NC DEPARTMENT OF
**HEALTH AND
HUMAN SERVICES**

July 22, 2024

RE: Jersey Mike's Subs
NC Hwy 210
Lillington, NC 28546

This letter acknowledges review of the plan for the above referenced establishment. The revised plans dated 07/16/24, application and email correspondence are approved with the following conditions:

1 EQUIPMENT PLAN
 1/4" = 1'-0"

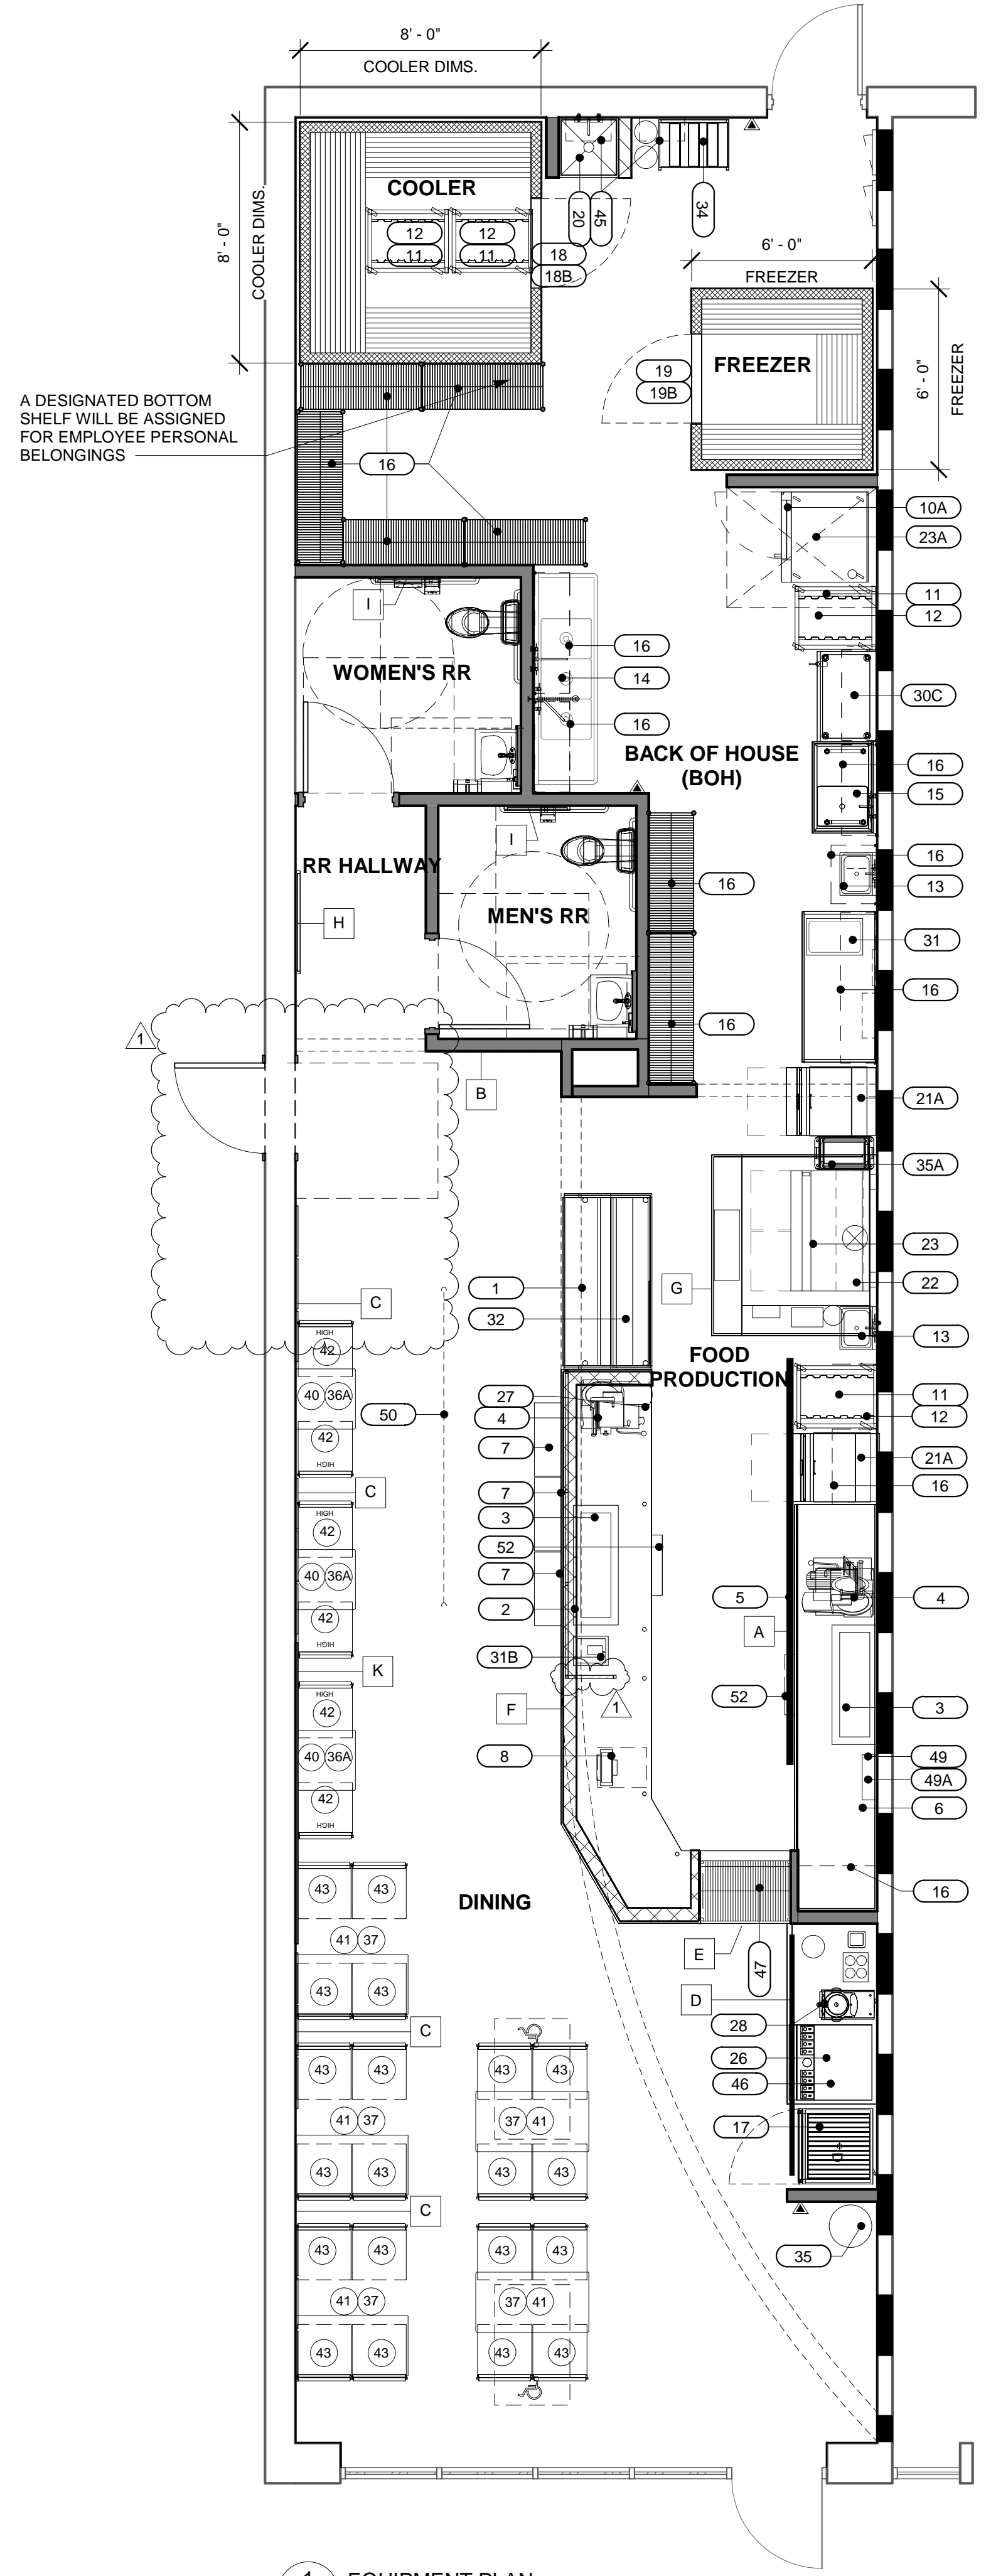
2. The Equipment Plan and Schedule EQ1.0 revised 07/16/24 is conditionally approved with the following considerations:
 - a. All food equipment, custom equipment, shelves, counters, and cabinetry must comply with subpart 4-205 of the North Carolina Food Code and be installed as specified in Sections 4-402.11 and 4-402.12 of the Code.

- b. The sneeze guard(s) will be installed 5' at finished floor and shall extend between the bacon warmer and POS as shown on revised plan sheet A4.0 and EQ1.

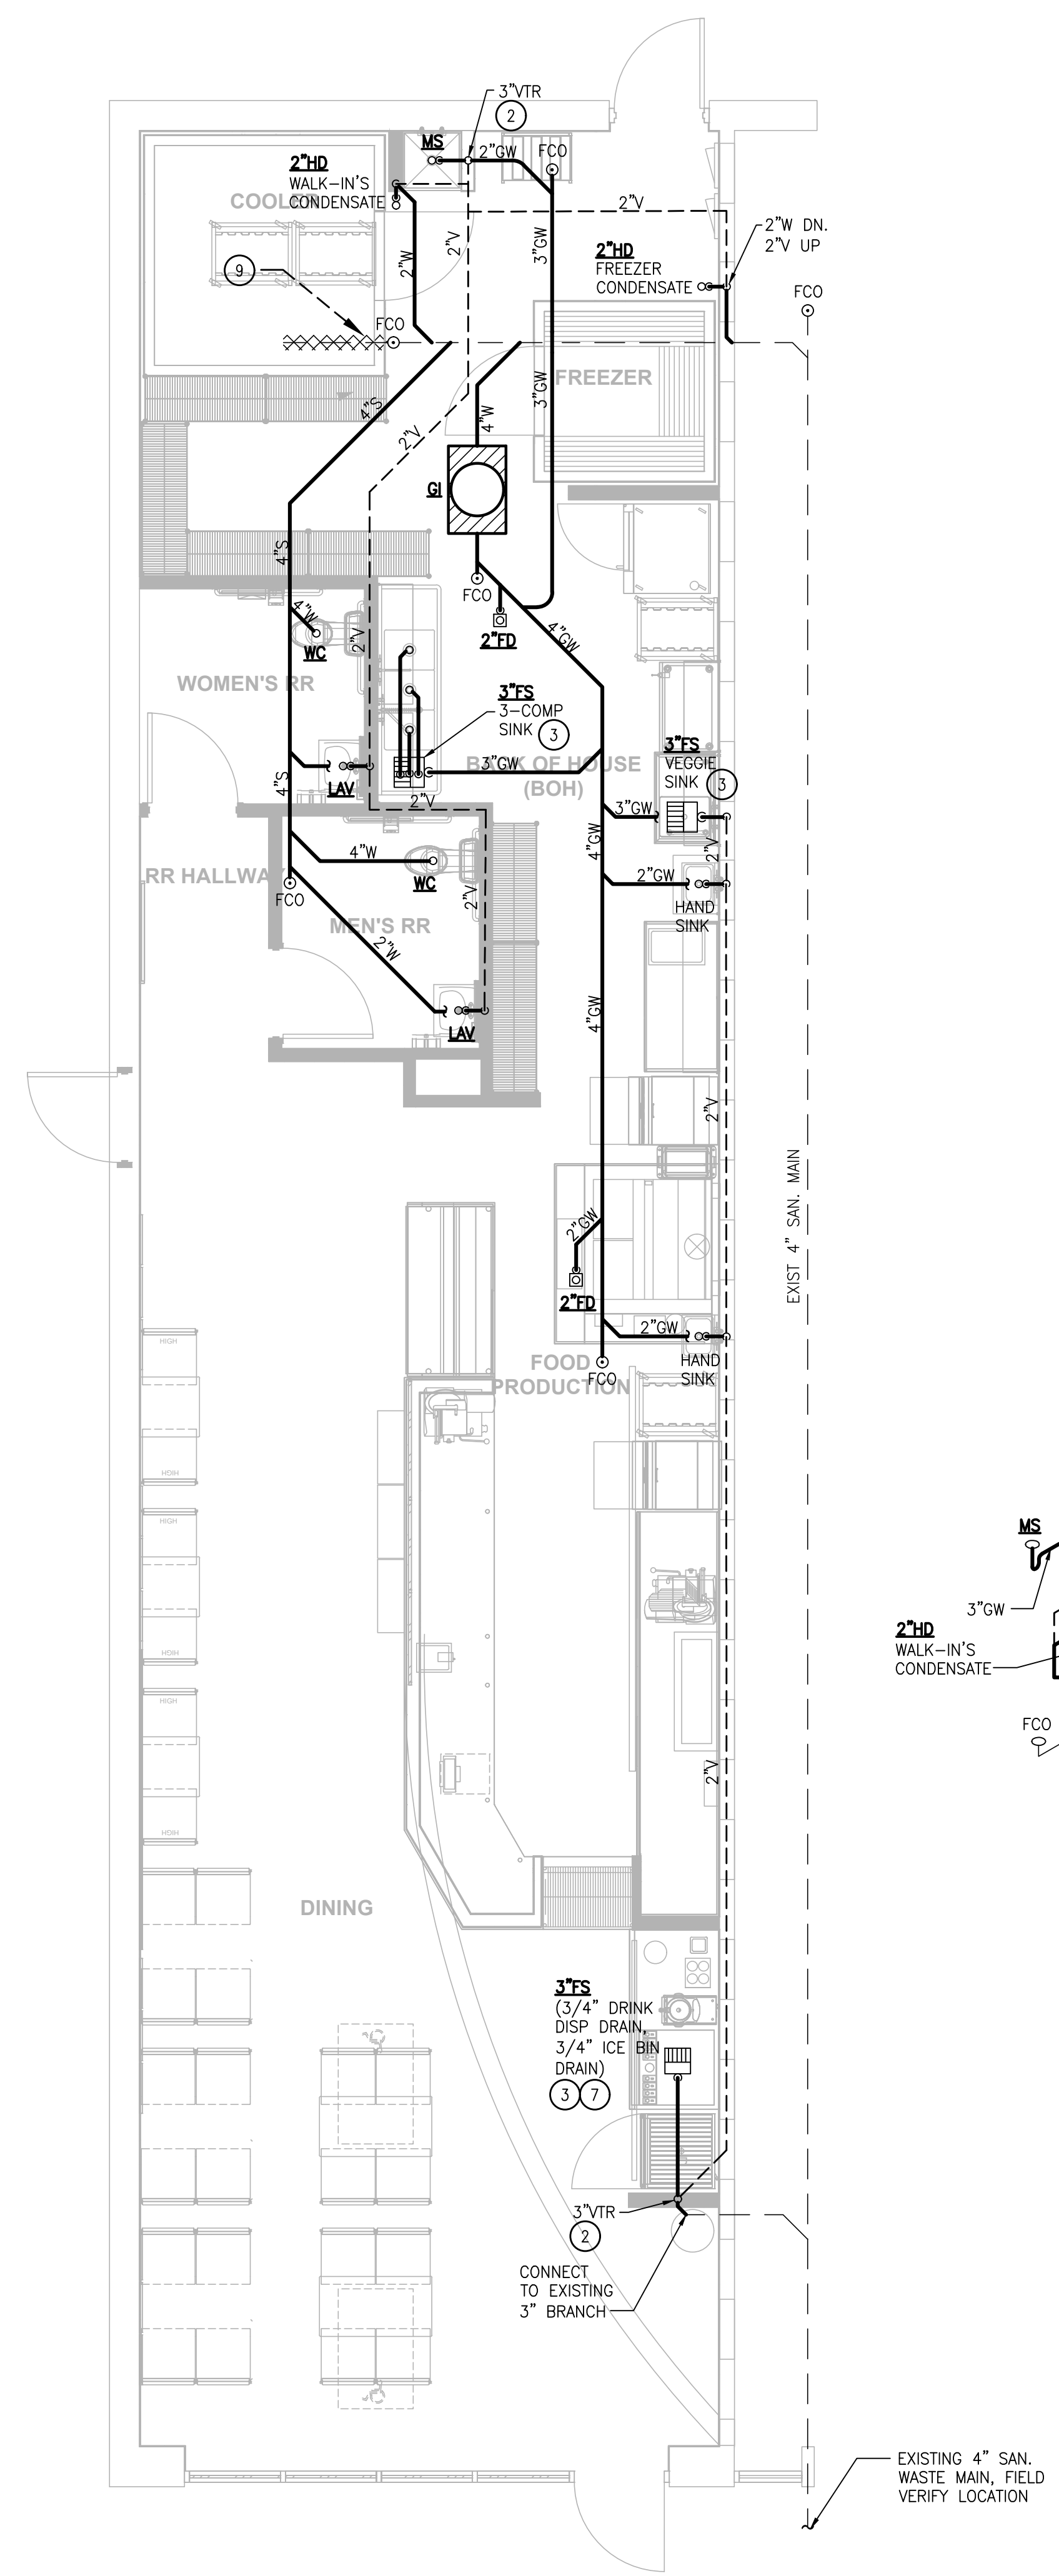
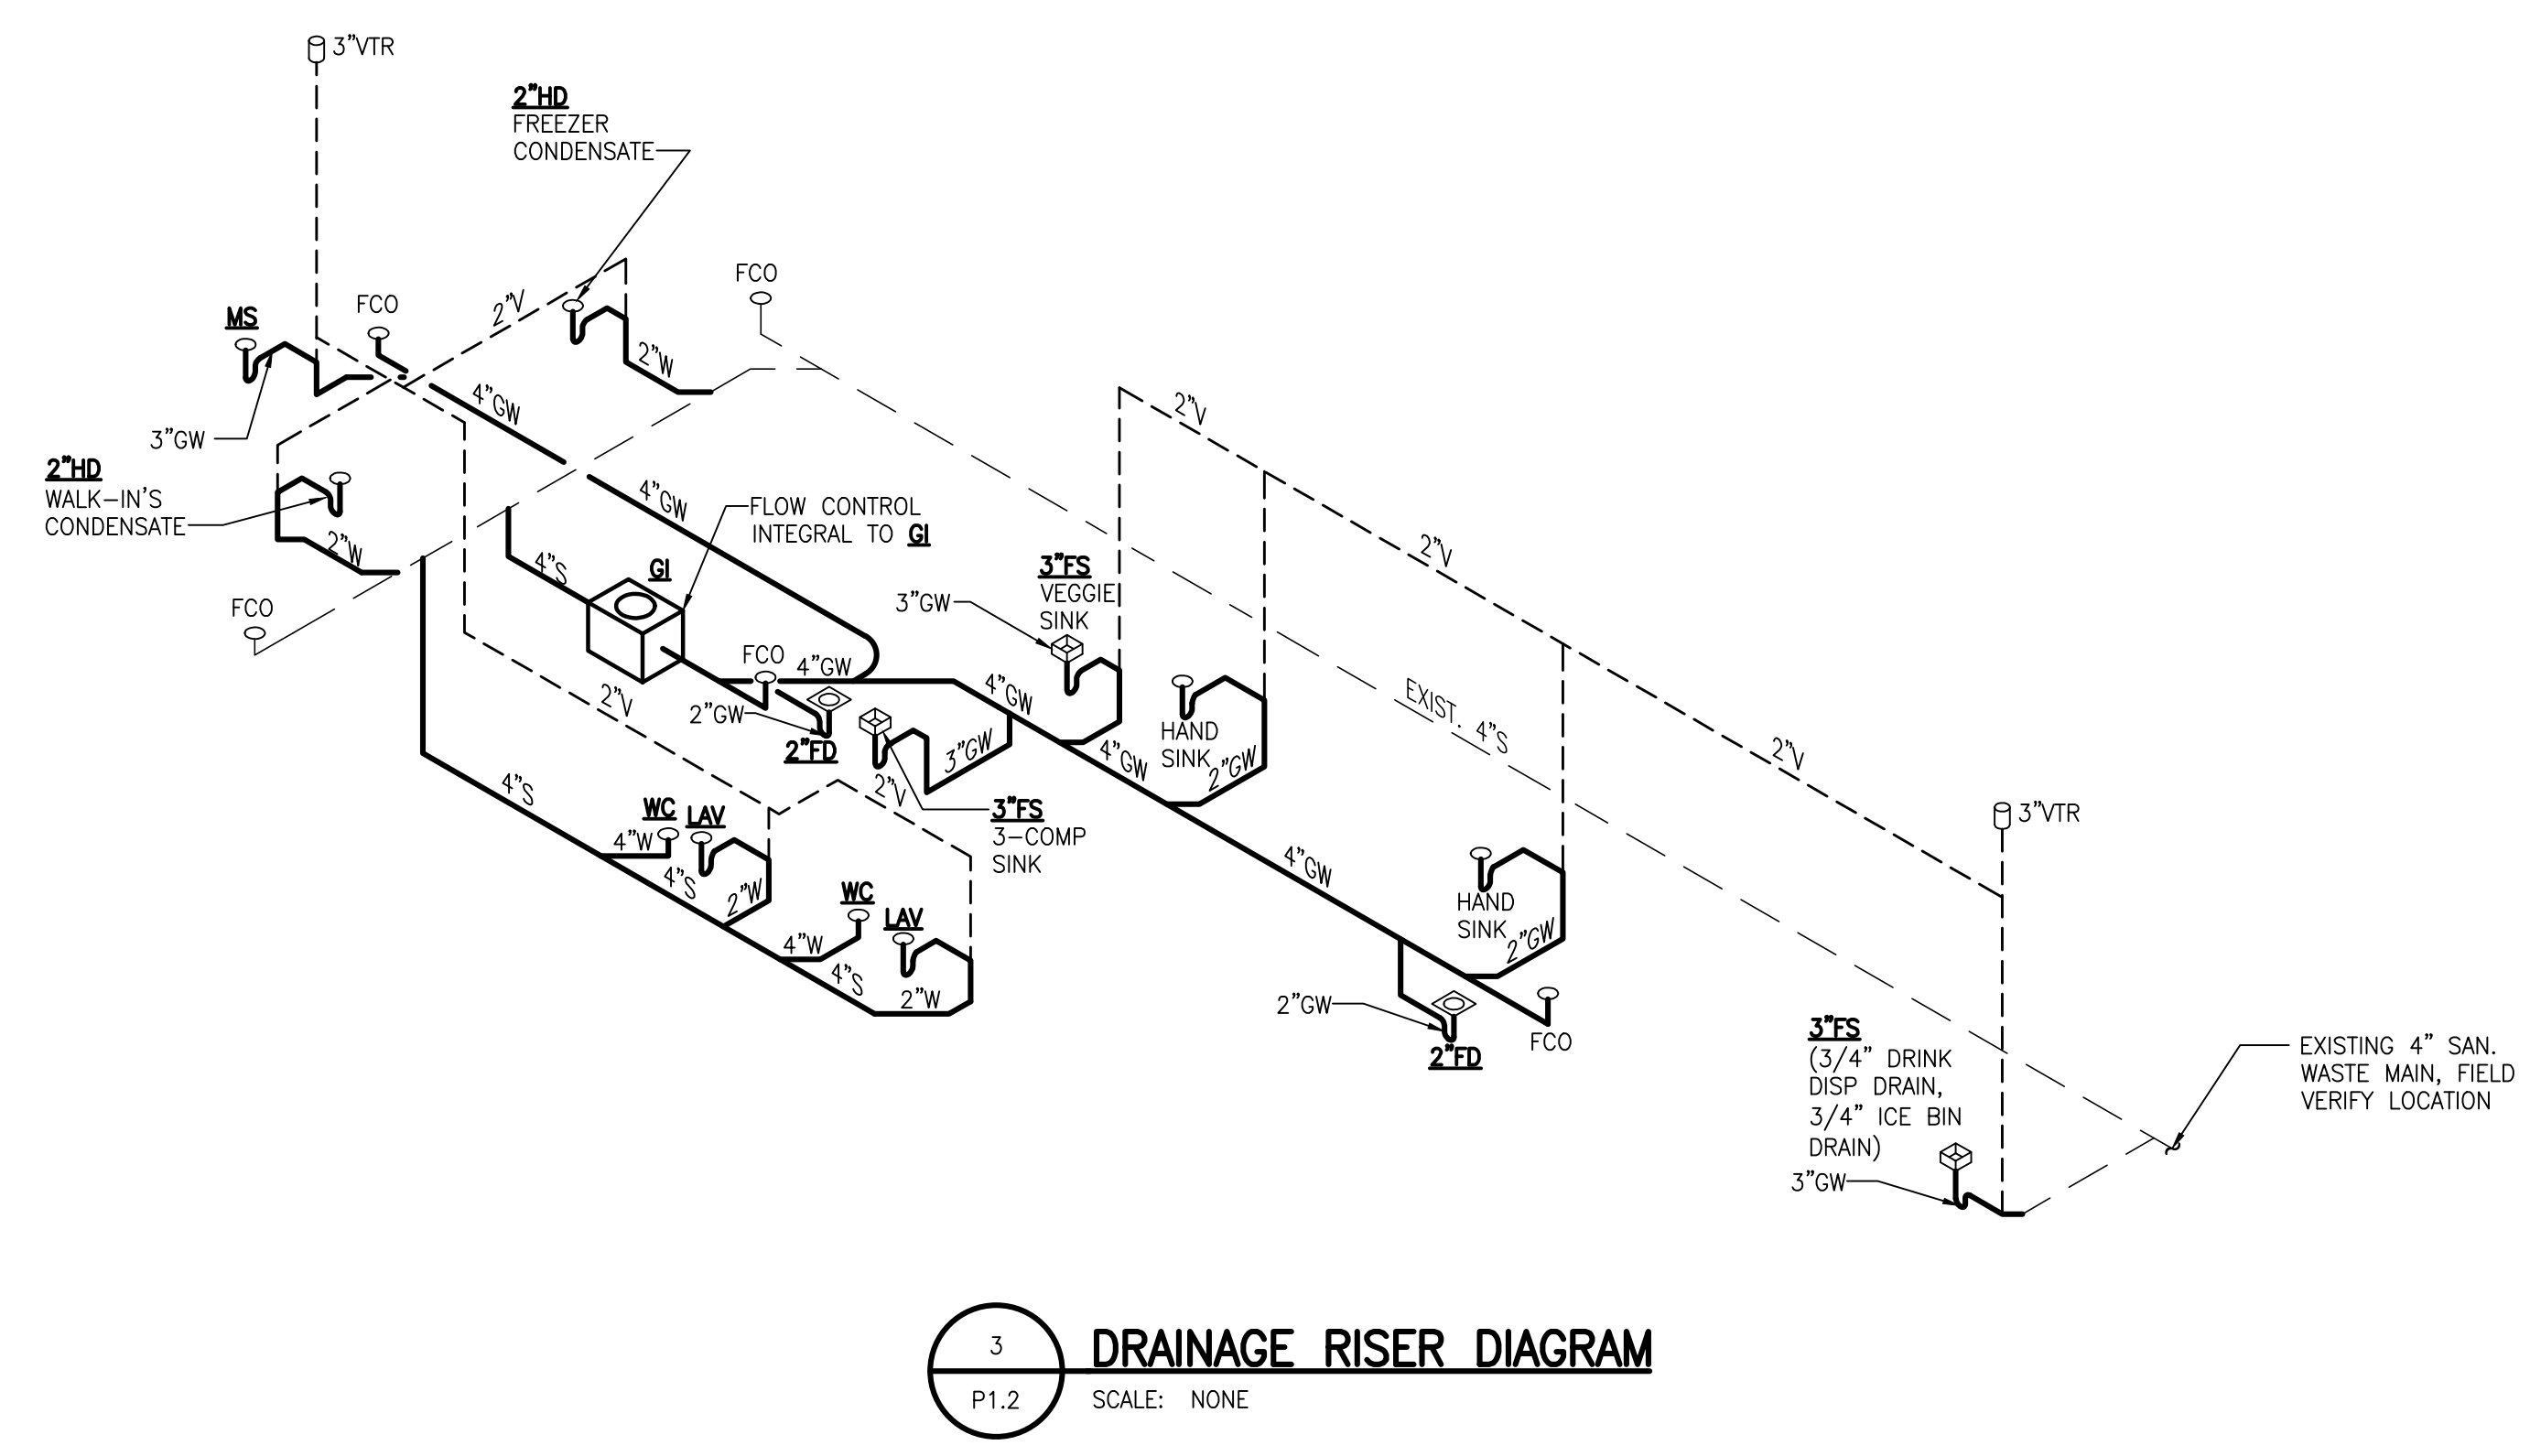
4. The plumbing, water and waste plans must comply with Parts 5-1 and 5-2 and Parts 6-1, 6-4 and 6-5 of the NC Food Code. The two 199,000 BTU tankless water heaters specified on the application and sheets P1.1, P1.2 are approved provided they provide sufficient hot water to all parts of the establishment. All exposed parts of the tankless water heater(s) should be installed so they are smooth, non-absorbent, and easy to clean.
